1.1 EXECUTIVE SUMMARY.

This Heritage statement has been prepared by Granit Chartered Architects for Mr. Damian Thornton in May 2021 to support an application for Listed Building Consent. This report has been updated and extended following Pre-application Advice in March -April 2021, and takes on board comments and requests from the Council made both during the Pre-App meeting and the subsequent report. Pre-Application Advice summary and response on following pages.

Pre-App Reference Number: 21/EQ/0042

**Typical Detail 01: Underfloor Heating to Lower Ground Floor**  
1:10

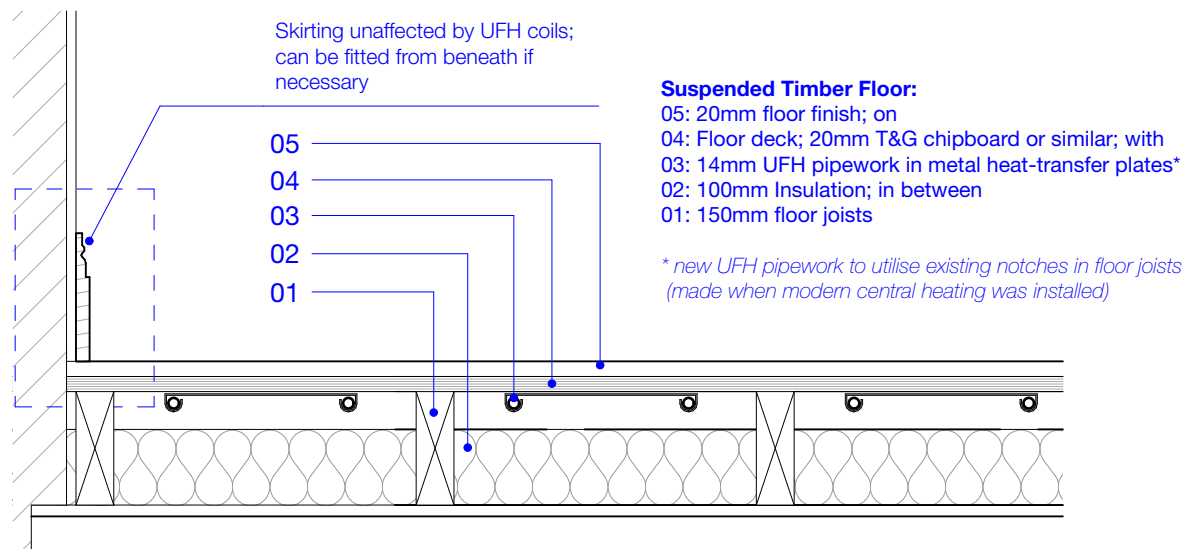
"Underfloor heating could be acceptable, subject to details of the impact on skirting boards – a section drawing at 1:5 or similar of proposed new flooring and relationship to skirting boards and other joinery where existing should be submitted as part of the application."

- As previously mentioned, proposals also include laying UFH to the newer sections of the lower-ground floor; namely the Kitchen and Dining Room. Similarly, the proposals involve the digging-up of the existing floor slabs and relaying at the same FFL, with under-floor heating loops laid into a concrete screed layer on top of the slab.

Drawing No. **2020/P/109**
 Drawing **Proposed Section E & F** Revision
 Purpose **FOR PLANNING**
 File CURRENT_CHAMPION_GROVE_LB_May.pln

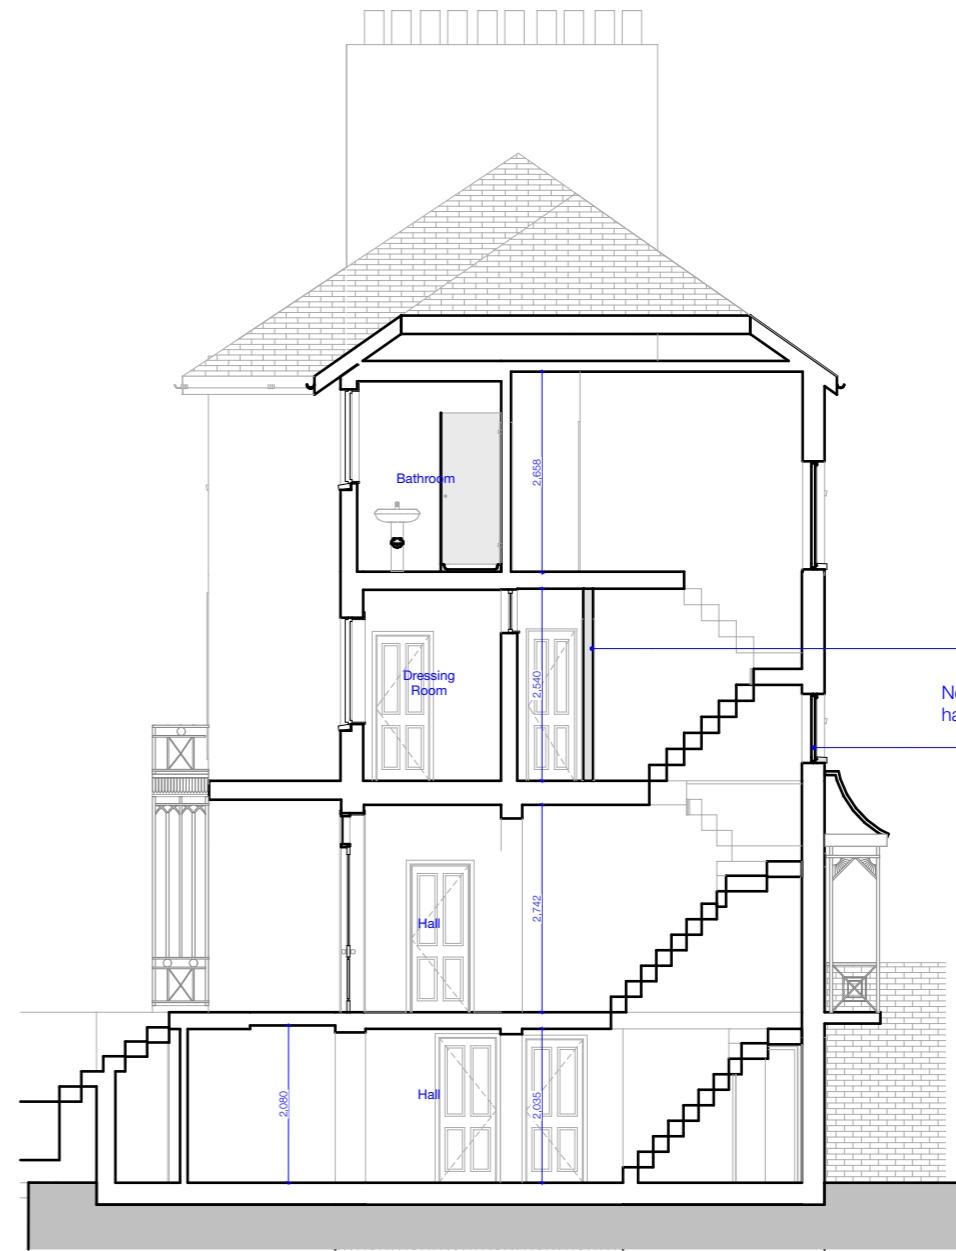
"This appears to be a modern 20th century floor and therefore would be acceptable."

- The Dining-Room extension is a modern addition, constructed c.1999.
- The existing floor build-up consists of a concrete slab with under-floor heating installed in a screed layer, with modern floor finishes internally.
- The lowering of this modern addition is not considered to impact the heritage of the existing building and the lowering of the floor level to align with the Kitchen would improve the functionality and accessibility of the space.
- The proposals do not alter the exterior of the building, nor the neighbouring properties and are not considered to damage the building's heritage value, as the fabric is wholly modern.
- In the previous application for Listed Building Consent; the lowering of the modern Dining-Room floor to align with the existing Kitchen FFL was considered acceptable. Email attached separately.

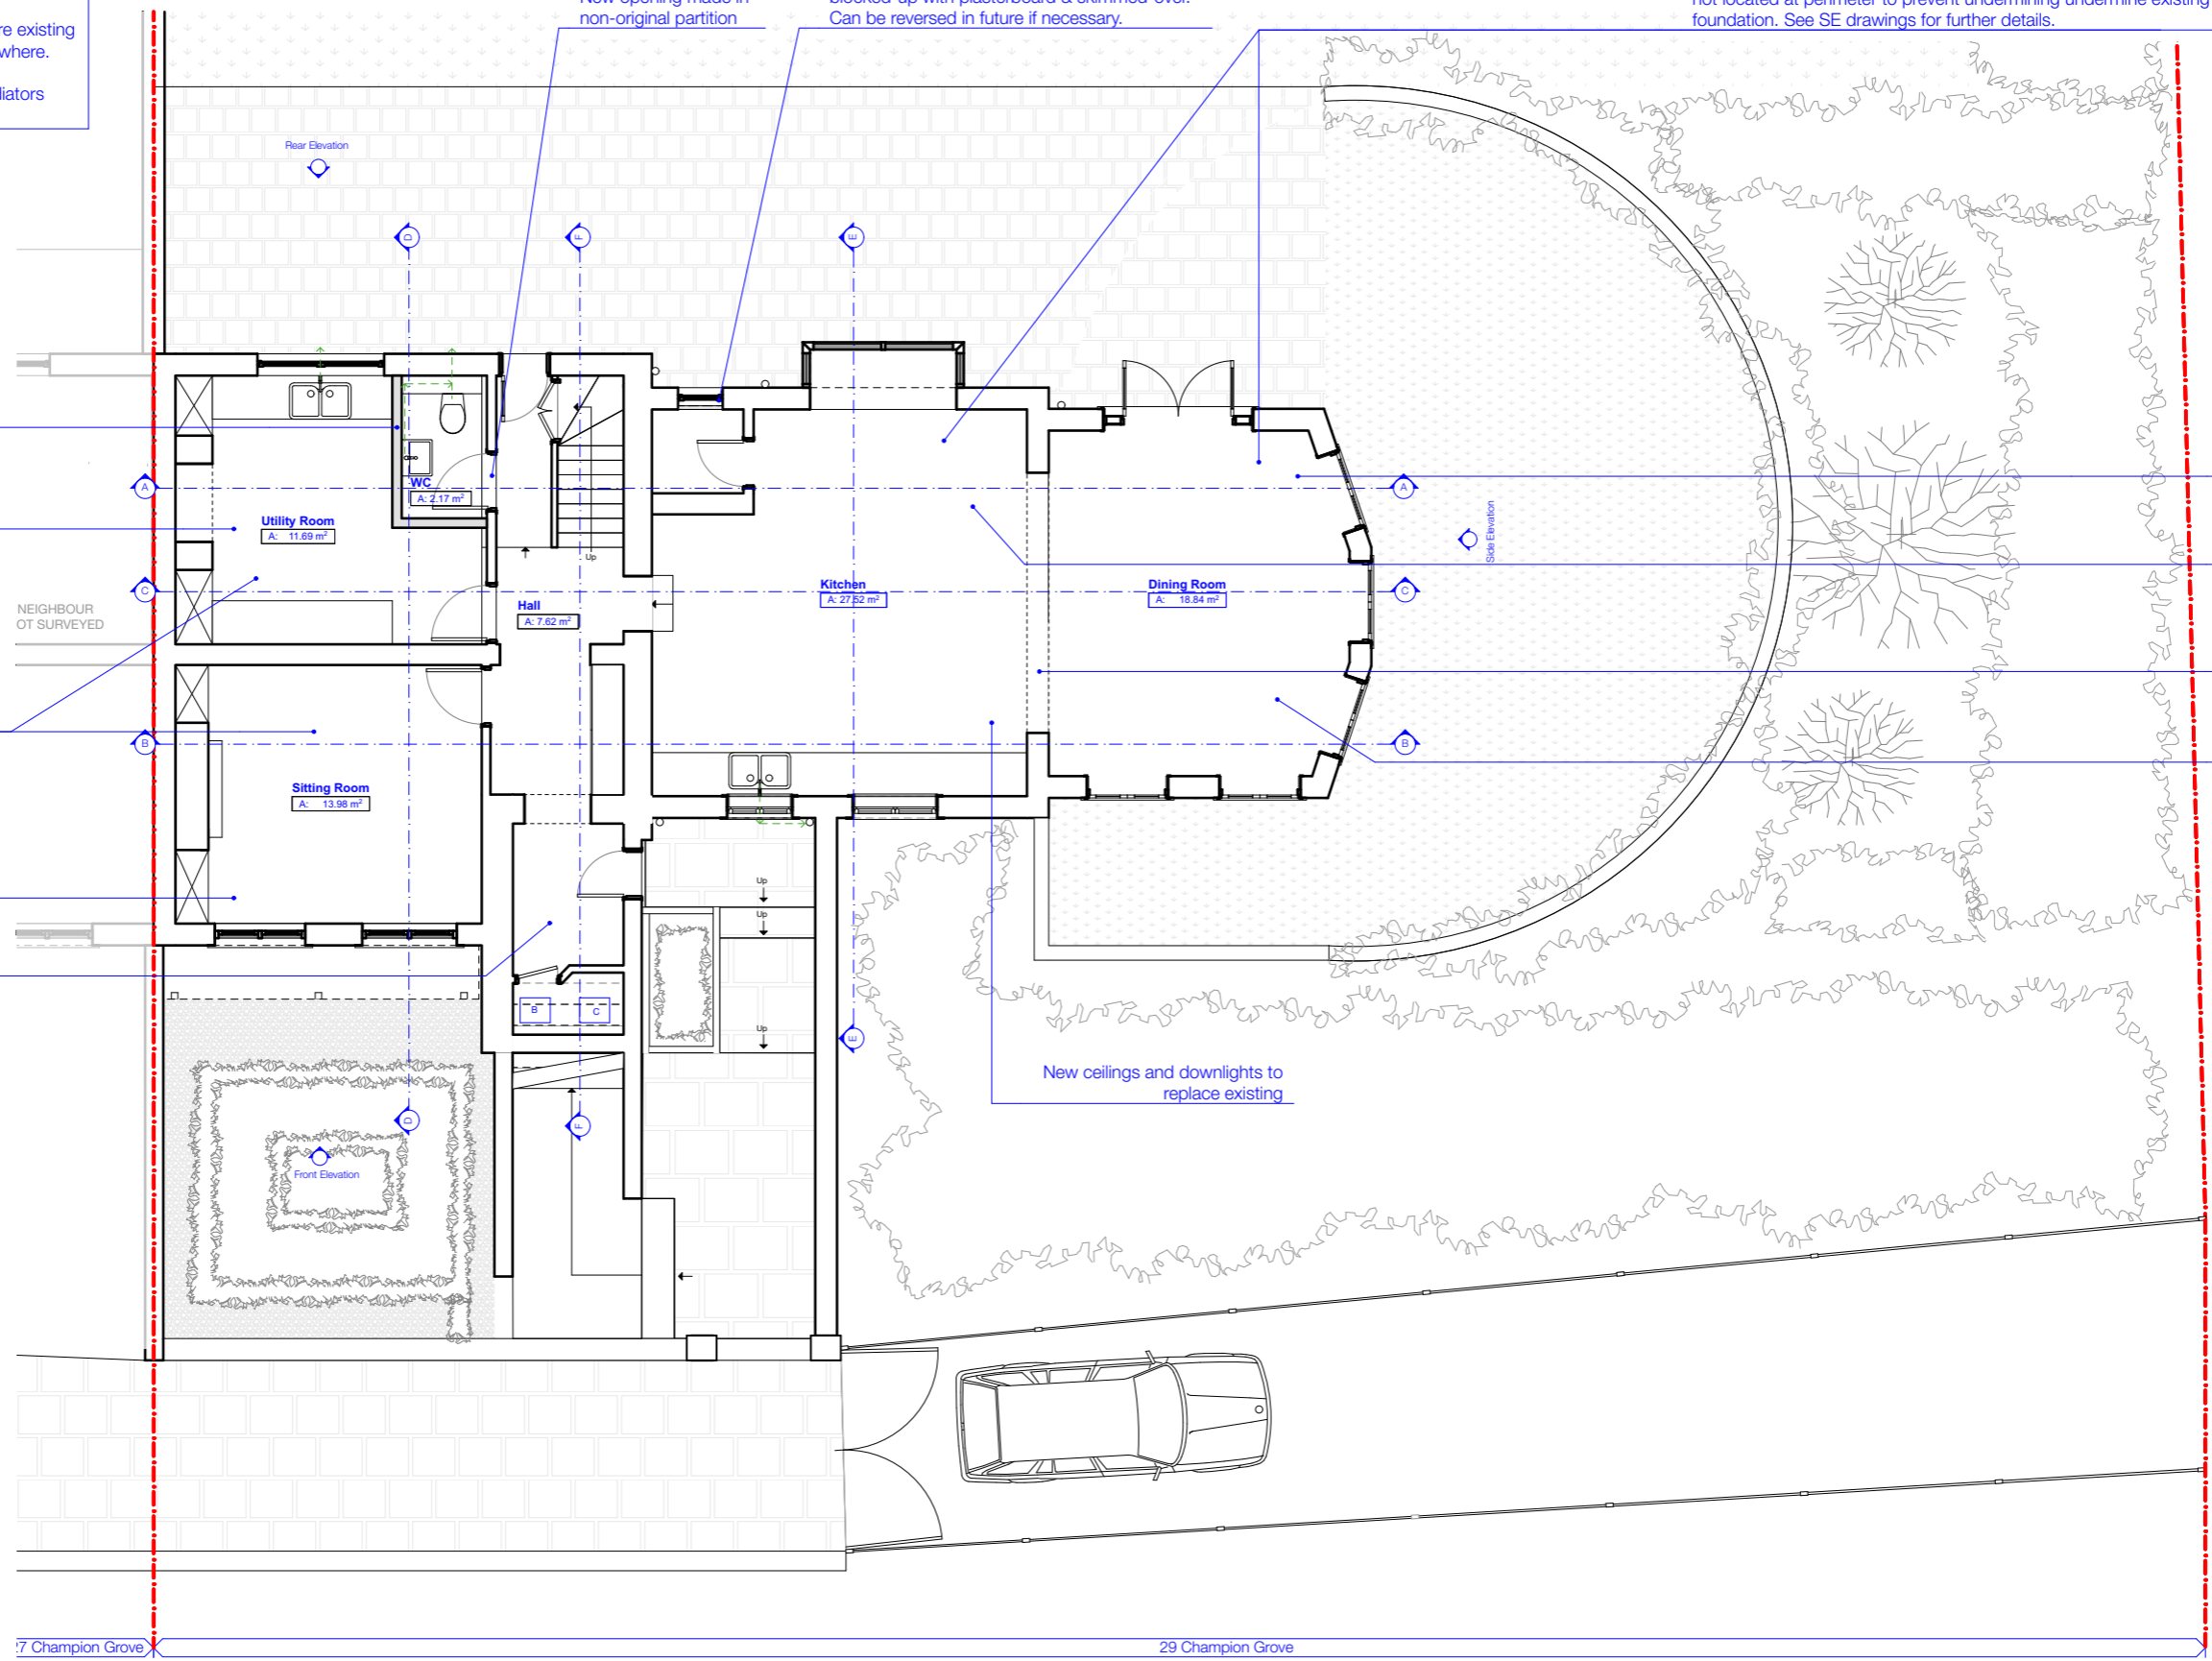
"The proposals require listed building consent, however the works to the chimney stacks are not supported without further information regarding historic fabric remaining behind modern plaster. This is required to ascertain the extent of chimney stacks at lower ground floor.

Some minor changes to the proposals are also recommended for the WC cloakroom at lower ground floor are also recommended as these elements may harm the significance of the grade II listed building.

As a result of the Pre-App meeting and report, strip-out works were carried out to ascertain the extent and condition of the existing chimney stack and existing masonry Hall/Utility partition at Lower Ground Floor.

Strip-out revealed that much of the original fabric has been cut to accommodate modern structure / services and in-filled with large areas of modern brickwork and cement mortar. As a result, the council confirmed that there is little of the original, historic fabric left to retain and therefore it's removal would be supported by the council.*

Local strip-out showed no evidence of historic fabric in this partition and therefore is considered unlikely to be original and therefore forming an opening in this wall is not considered by the council to be detrimental. As a result, the council confirmed that there is unlikely to be original, historic fabric and therefore it's alteration would be supported by the council.*
